TECHNICAL NOTE			
from:	ALAN DAVIES	date:	28/3/2022
subject:	Land at the North of the Chapel Hill site Longridge for the erection of 4no. commercial units (Use Class E).	file ref:	J1354-TN1A

This Technical Note sets out the response to the feedback as an addendum in rev A in red for ease of reference.

Project  
**LAND AT CHAPEL HILL,  
 LONGBRIDGE, PRESTON, PR3 3BU**  
 PLANS & ELEVATIONS AS PROPOSED

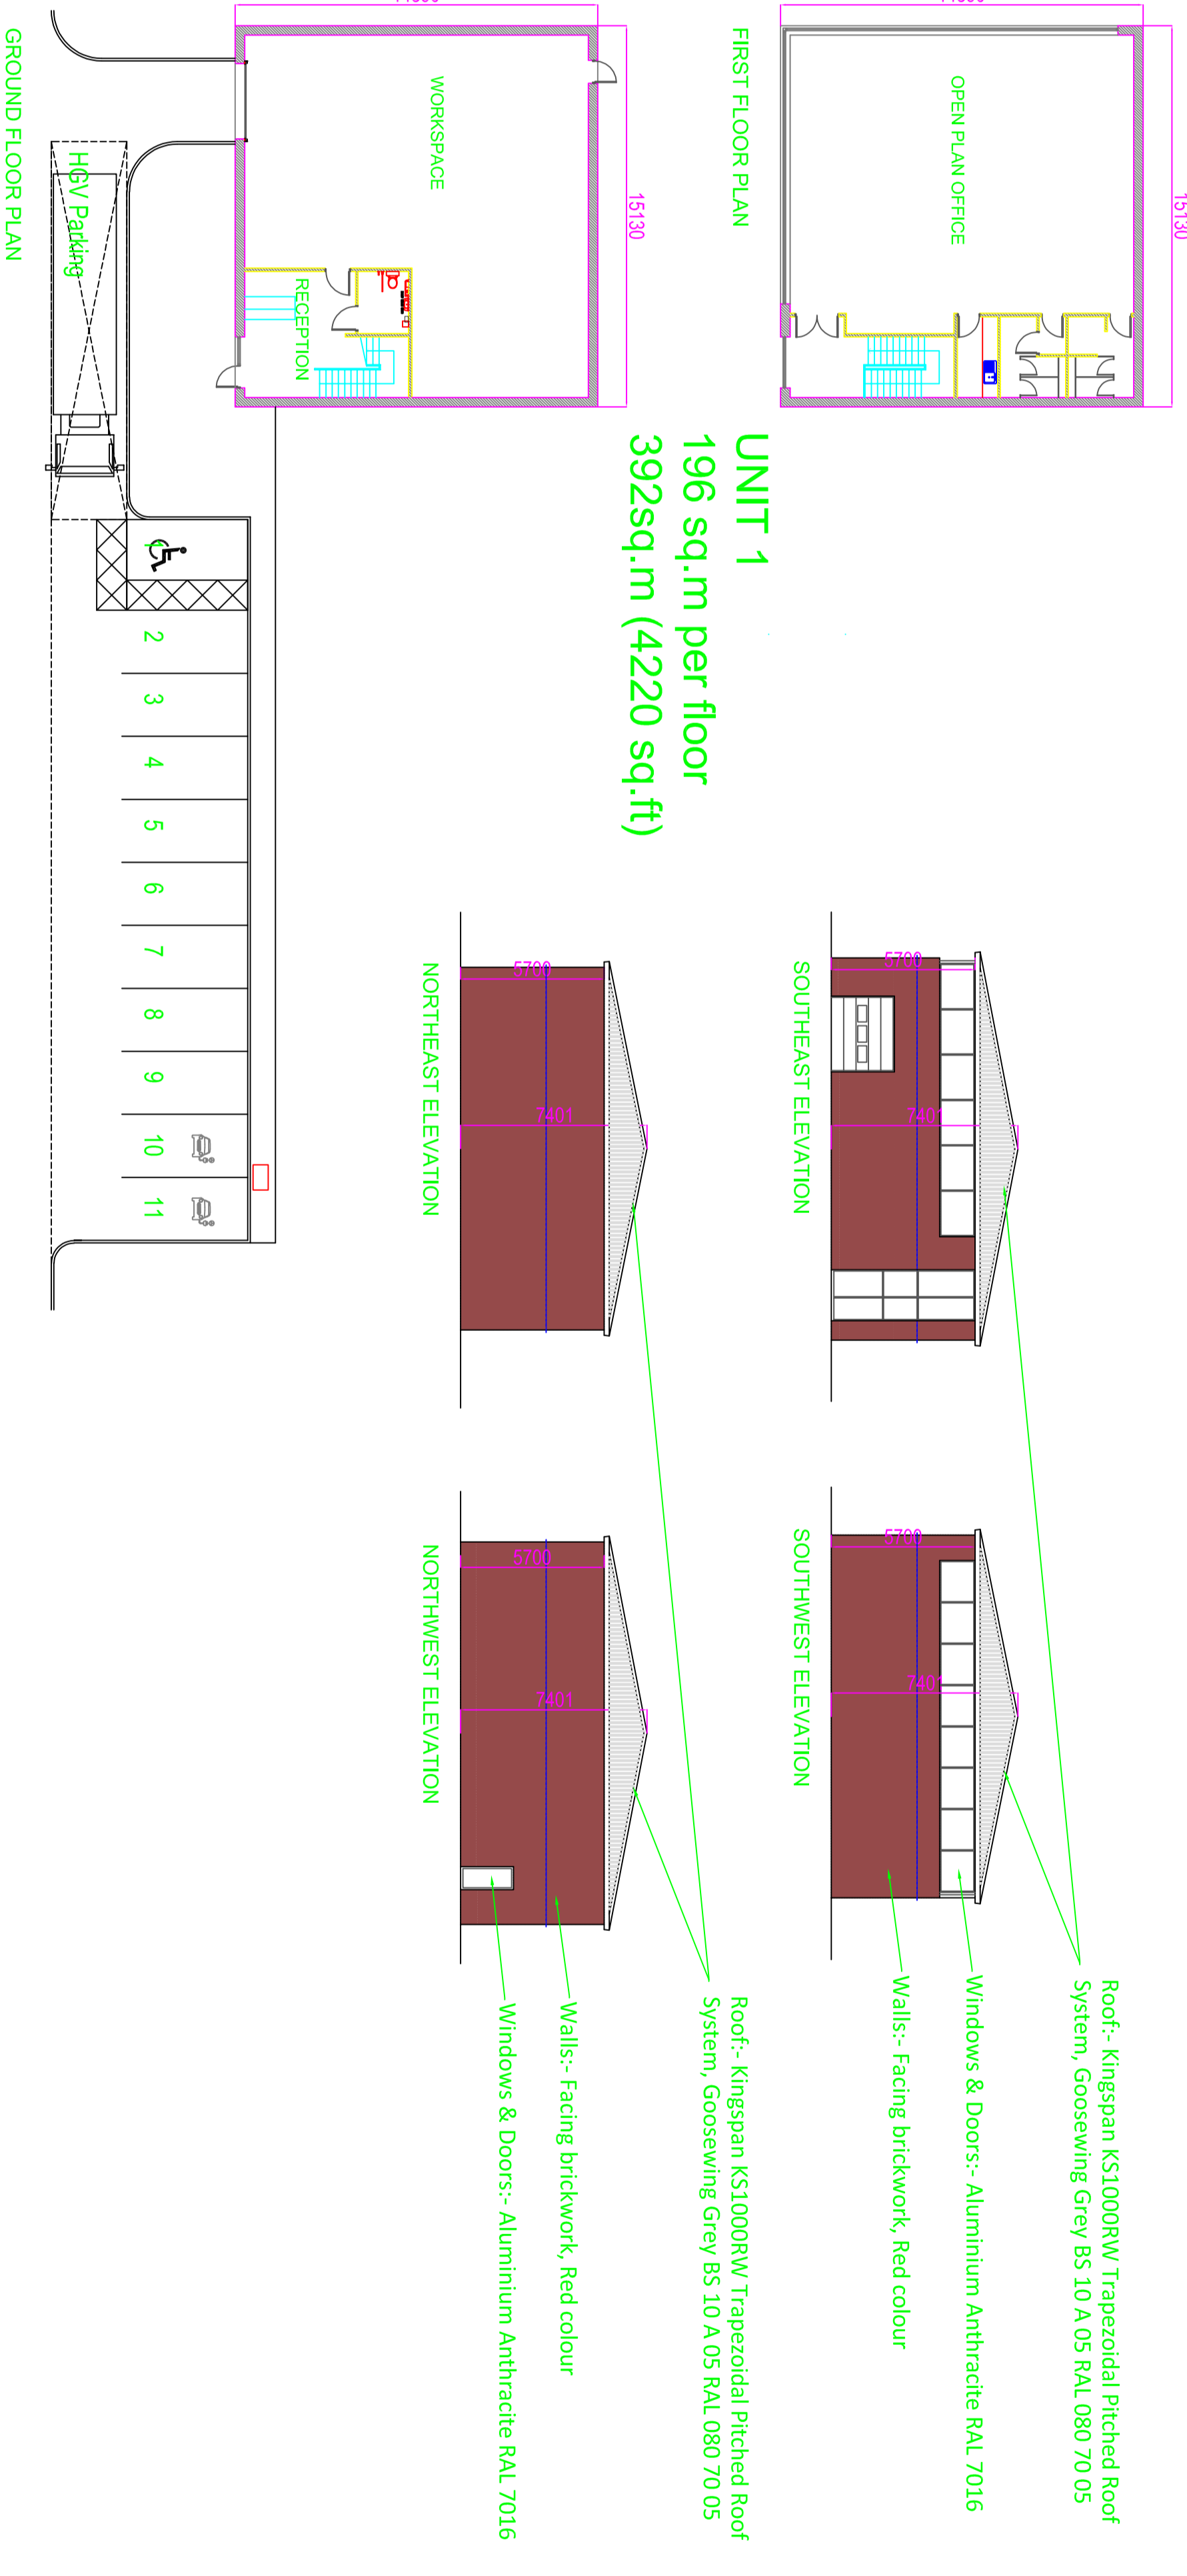
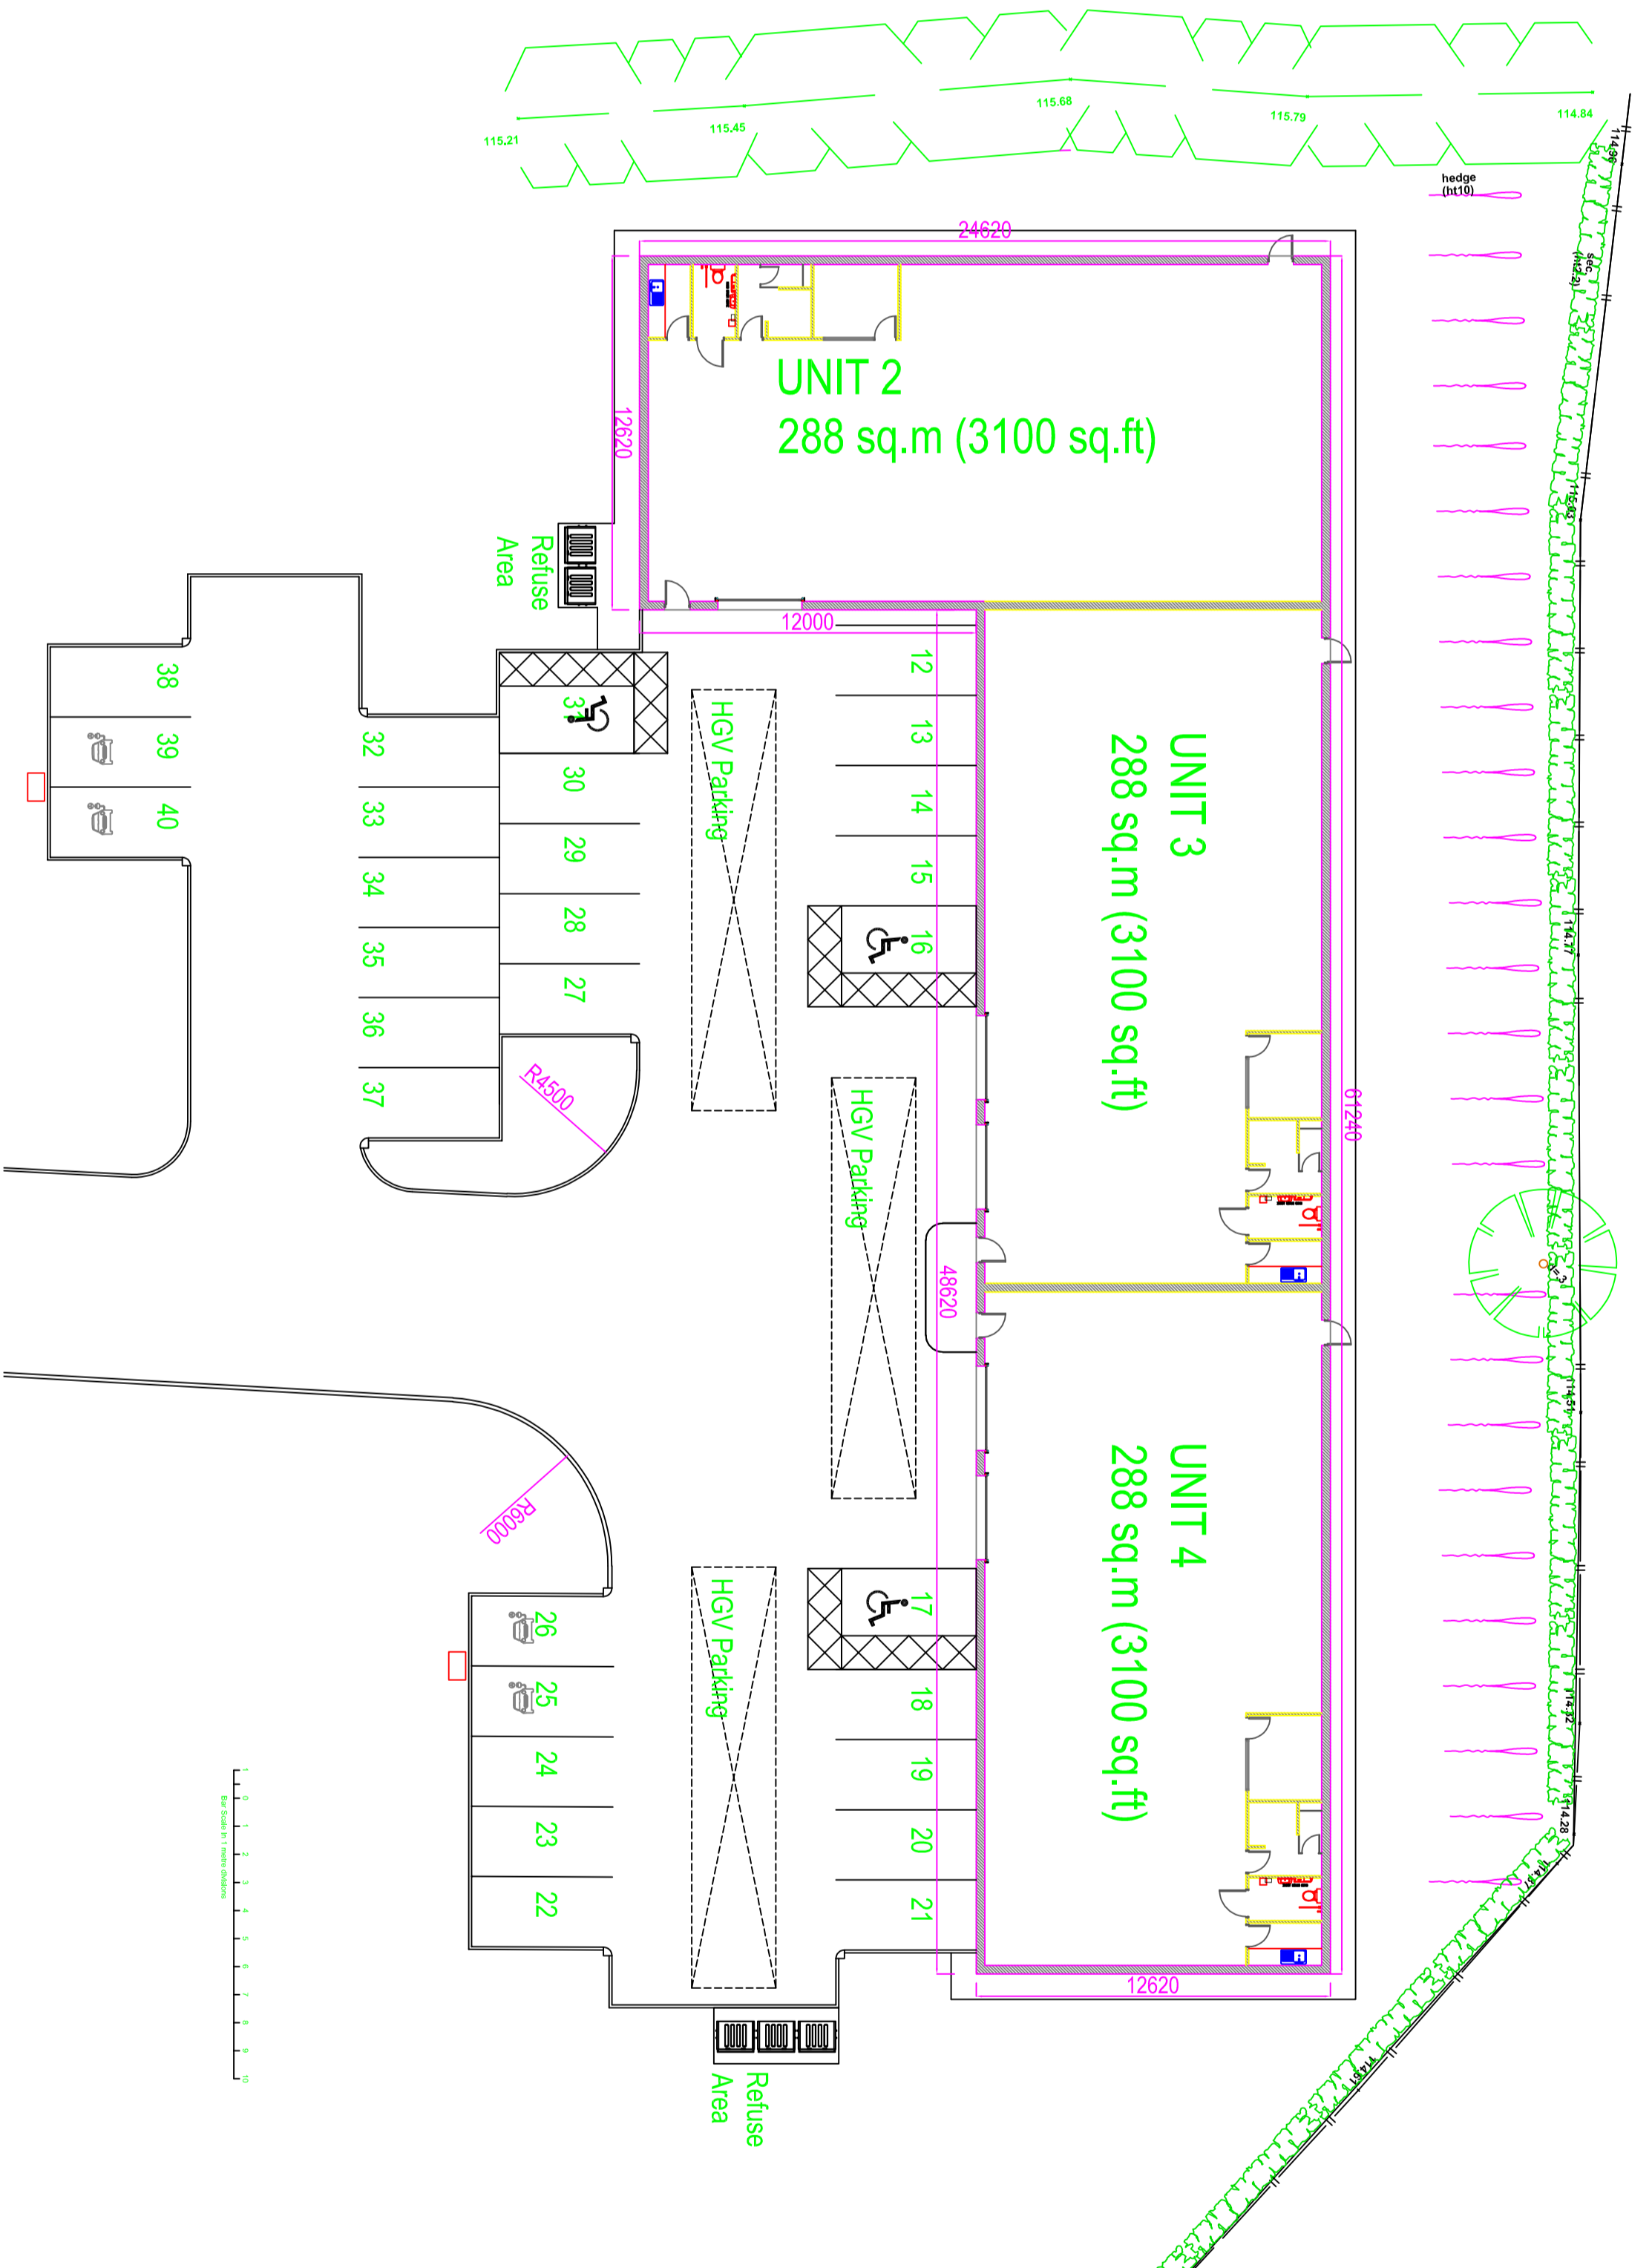
The LHA have reviewed IP drawing number 3 Rev B titled "Plans and Elevations As Proposed" and are aware that the site will provide 30 car parking spaces for the proposal. This however does not comply with the parking standards found in the Joint Lancashire Structure Plan, which requires a B1 development in Longridge with the internal floor area of 1256 square metres (sqm) to provide 40 car parking spaces.

It is worth noting that the LHA are aware that the site is in close proximity to bus stops which serve services to Preston and the Longridge area. However, should visitors to the site travel from outside these areas, the most likely mode of travel is by vehicle leading to the need for further car parking spaces to serve the site. Therefore, the LHA require the additional 10 spaces to enable the site to comply with the LHAs guidance. This should be shown on a revised plan.

The LHA also require on the revised plan a loading area for Unit 1. This is because currently there is no area for servicing for Unit 1 and so the LHA are concerned that any servicing vehicles will block the use of the internal road into and out the site. The LHA advise that the area should be located adjacent to the Unit,

The dimensions of the loading area should be a minimum of 2.4m x 15m as a guide to enable Heavy Good Vehicles (HGV) to use the space but the LHA will require a tracking drawing to ensure that the proposed dimensions are adequate

The LHA require the space to be large enough for an HGV to use because there is a lack of designated areas for HGVs to park within the site. Not only this but should an HGV or another delivery vehicle be servicing one of the other units, the area can then be used as a waiting area until the vehicle exits the site.

The parking offered was based on location and operational needs of the site which is based on the national policy framework, the increase to 40 to meet the maximum policy levels ignores this however the extra 10 spaces are shown on the revised drawings and the abstract below.

Spaces 37 to 40 will be designed as overspill spaces i.e. crushed stone construction to be used if and when needed.

A maximum rigid vehicle of 12m has been tracked for the revised internals, the spaces are designed to accommodate the size of vehicle and other than at unit 1 no requirement to mark out as they form the aisles etc.
